City of Portland, Maine - Building or Use Permit Application
 389 Congress Street, 04101 Tel: (207) 874-8703, Fax: (207) 874-8716

Permit No: 09-0846	Issue Date:	CBL: 048 C015001
------------------------------	--------------------	----------------------------

Past Use: Multi Family / 6 Units	Proposed Use: Multi Family / Amendment to permit # 090265 change from flat roof to trussed roof, resupport posts in basement and rebuild front stairway.	Permit Fee: \$70.00	Cost of Work: \$5,000.00	CEO District: 2
Proposed Project Description: Amendment to permit # 090265 change from flat roof to trussed roof, resupport posts in basement and rebuild front stairway.		FIRE DEPT: <input type="checkbox"/> Approved <input type="checkbox"/> Denied	INSPECTION: Use Group: Type	
		Signature:	Signature:	
PEDESTRIAN ACTIVITIES DISTRICT (P.A.D.)				
Action <input type="checkbox"/> Approved <input type="checkbox"/> Approved w/Condition <input type="checkbox"/> Denied				
Signature: Date:

ROOF SECTIONS

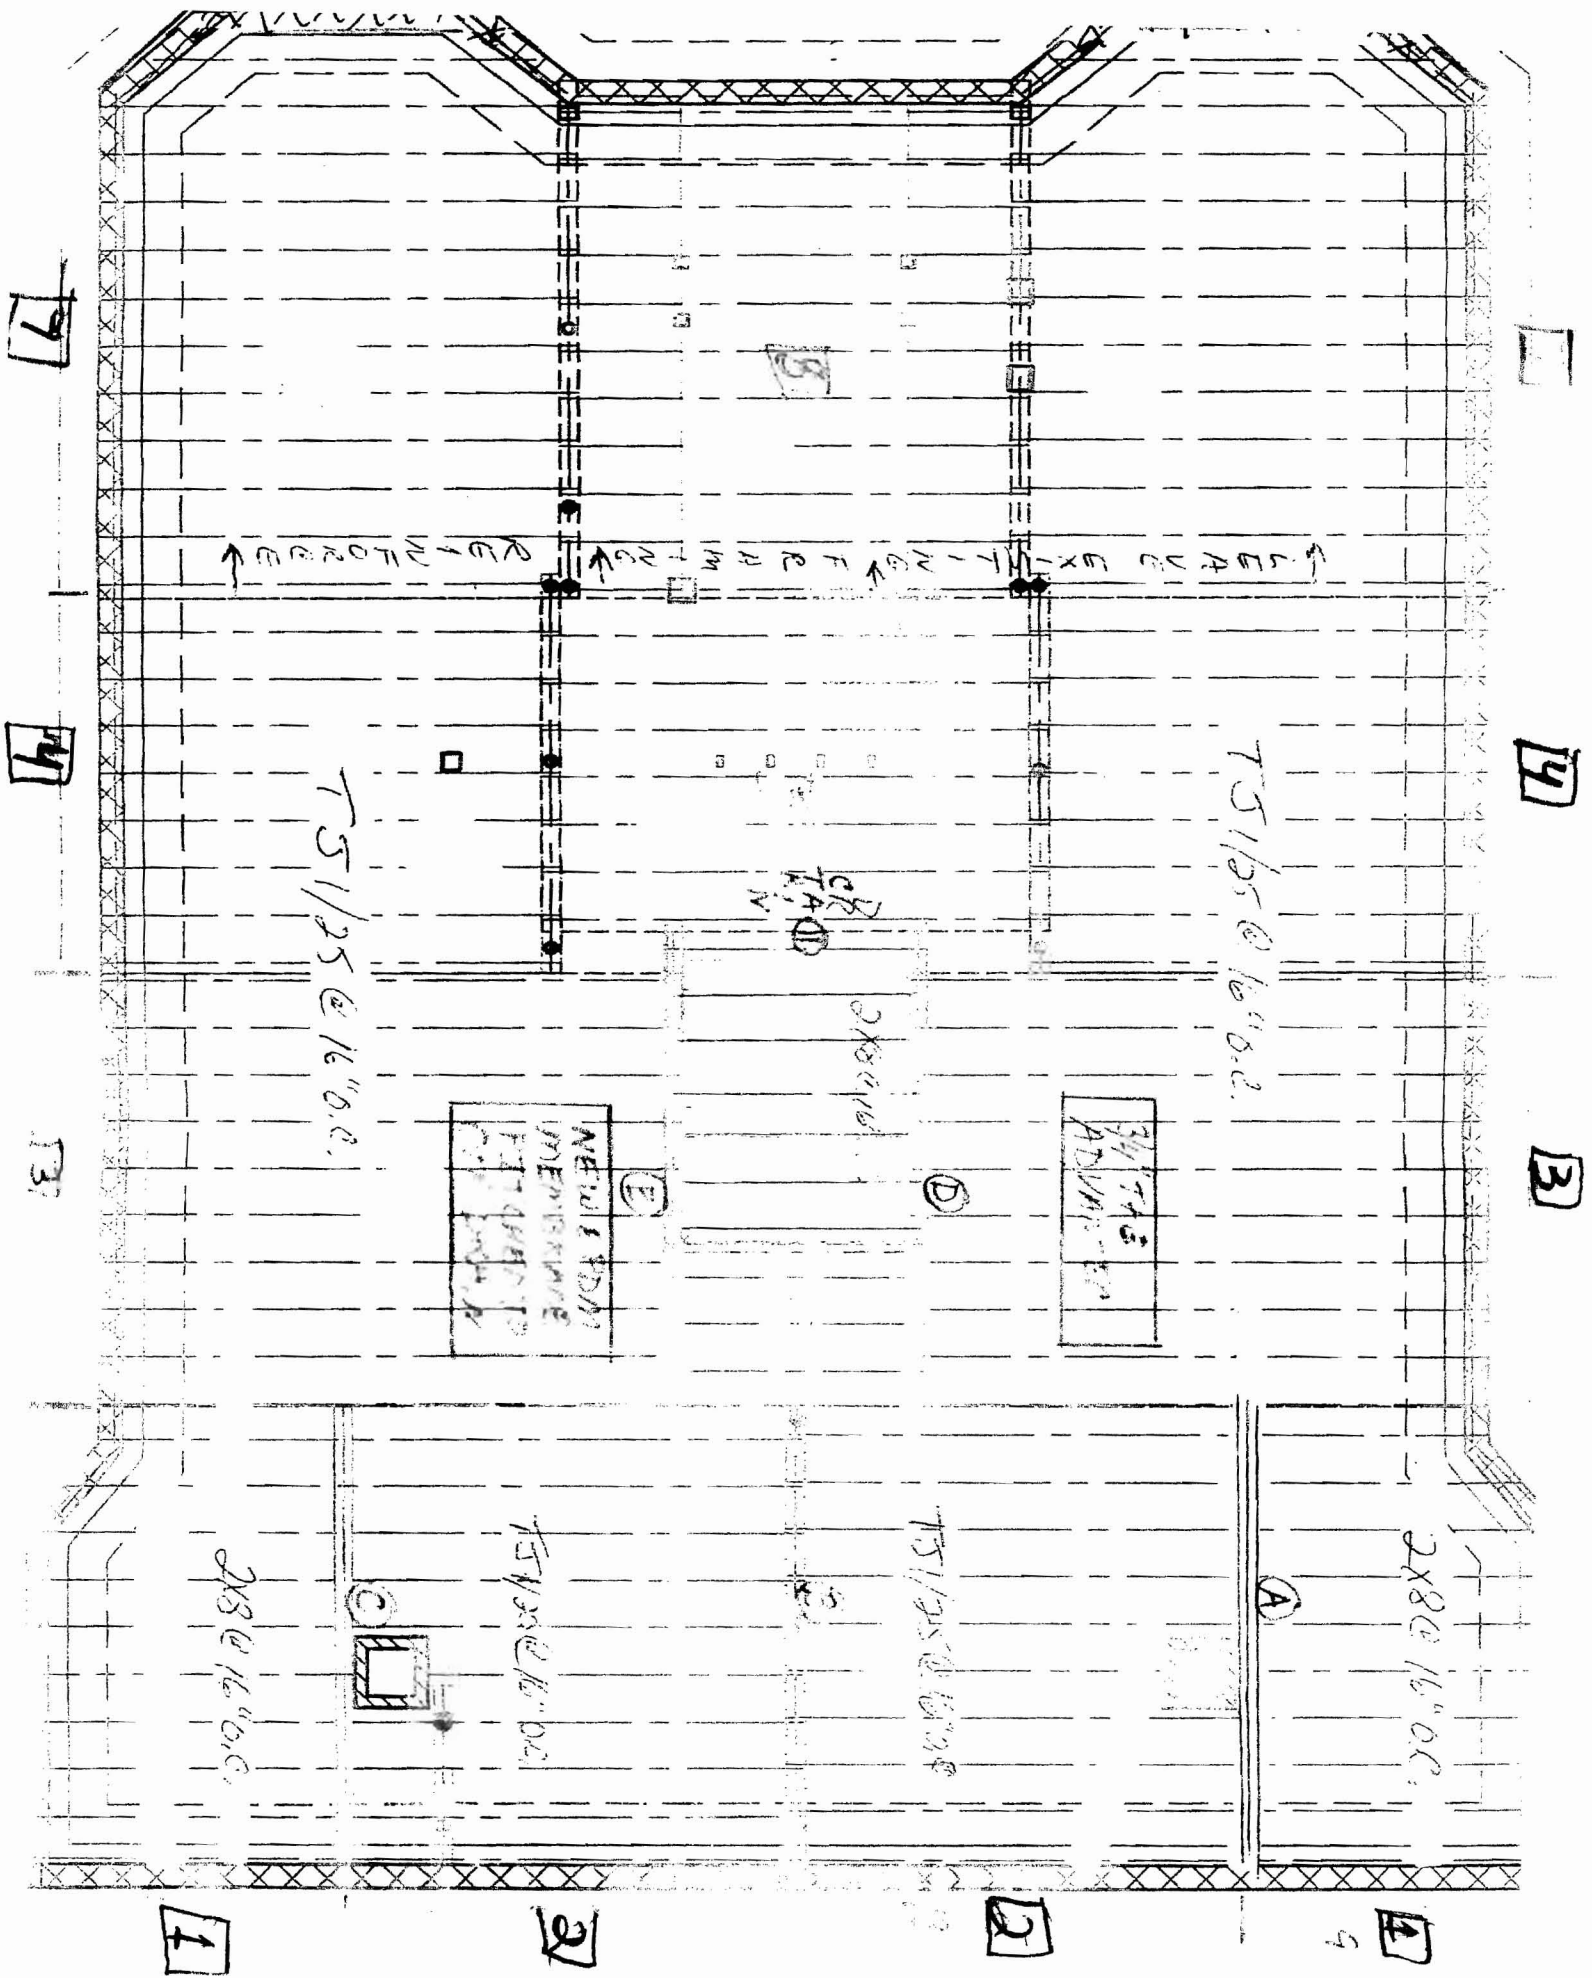
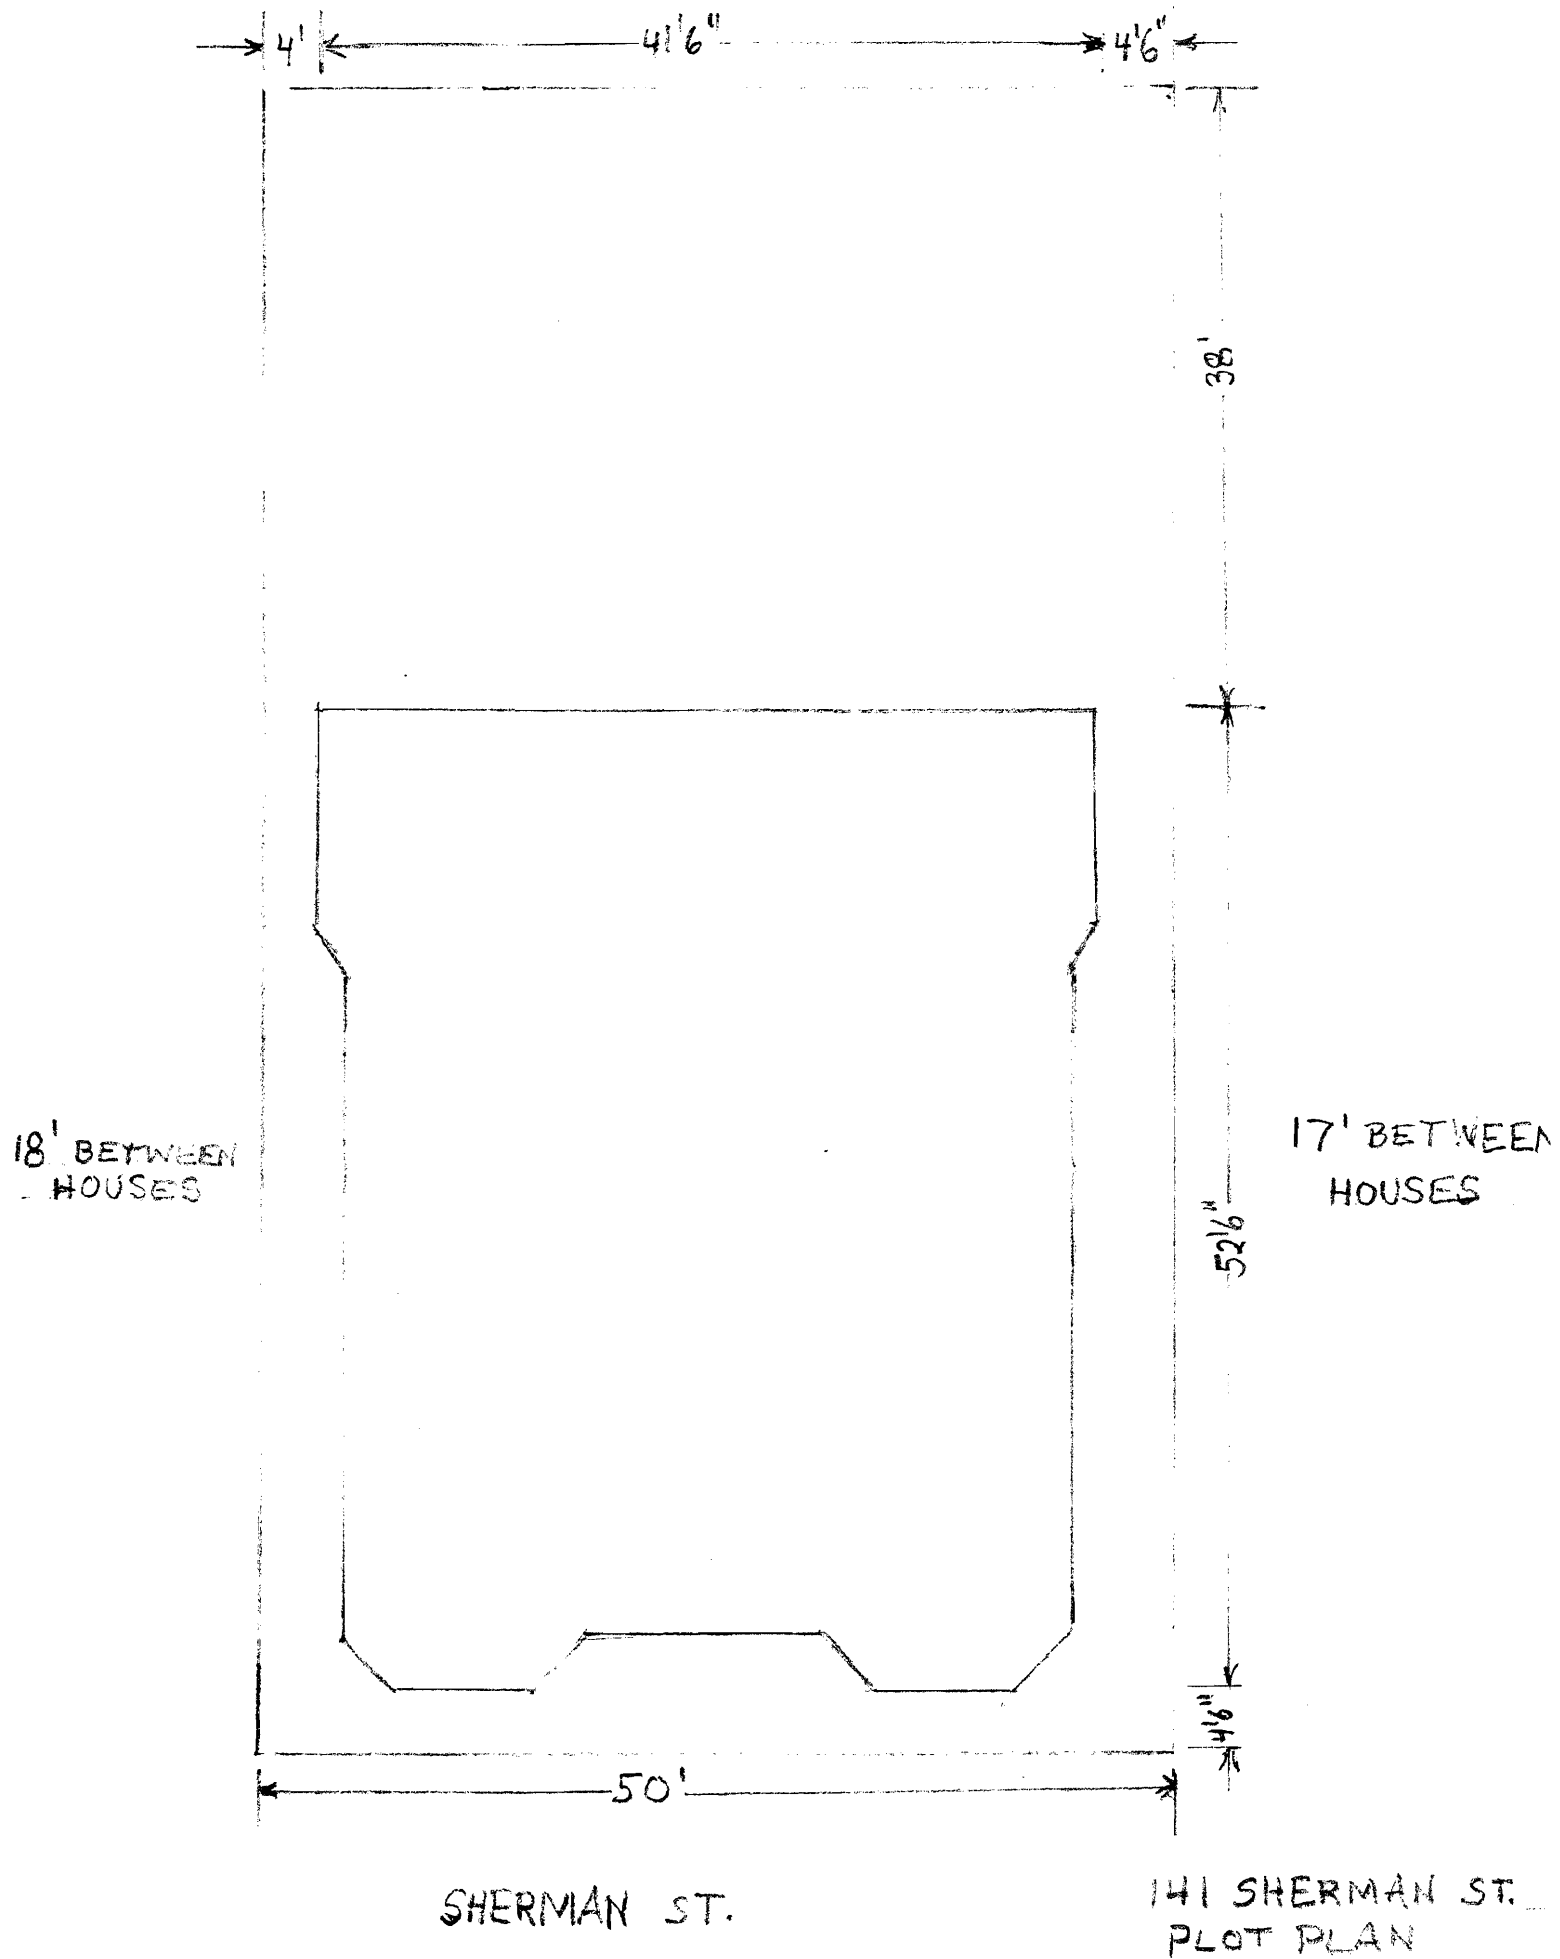
8/19/2009-amachado: Left vcm for James Harmon. Checking that 5/12 pitch and asking whether he is creating any floor area with changing the roof. Also is the front stair work on the interior of the building?

8/27/2009-jmb: Spoke to contractor about the roof trusses, if existing flat roof to be removed. The fire damaged area will and new walls will be built to accommodate load, new plate on existing roof to fasten trusses. Need framing plan for reconfiguration of new front stairway and discussed handrails on both sides - continuous inside. He will submit

8/19/2009-amachado: Jim Harmon left me a vcm. There will be no floor area created by going from a flat roof to a pitched roof, just trusses no floor area. The rebuild of the front stairway is internal replacing existing front stairway.

8/28/2009-jmb: Contractor submitted details for guards and rails and showed the bearing beams in basement for the new stair configuration. Ok to issue.
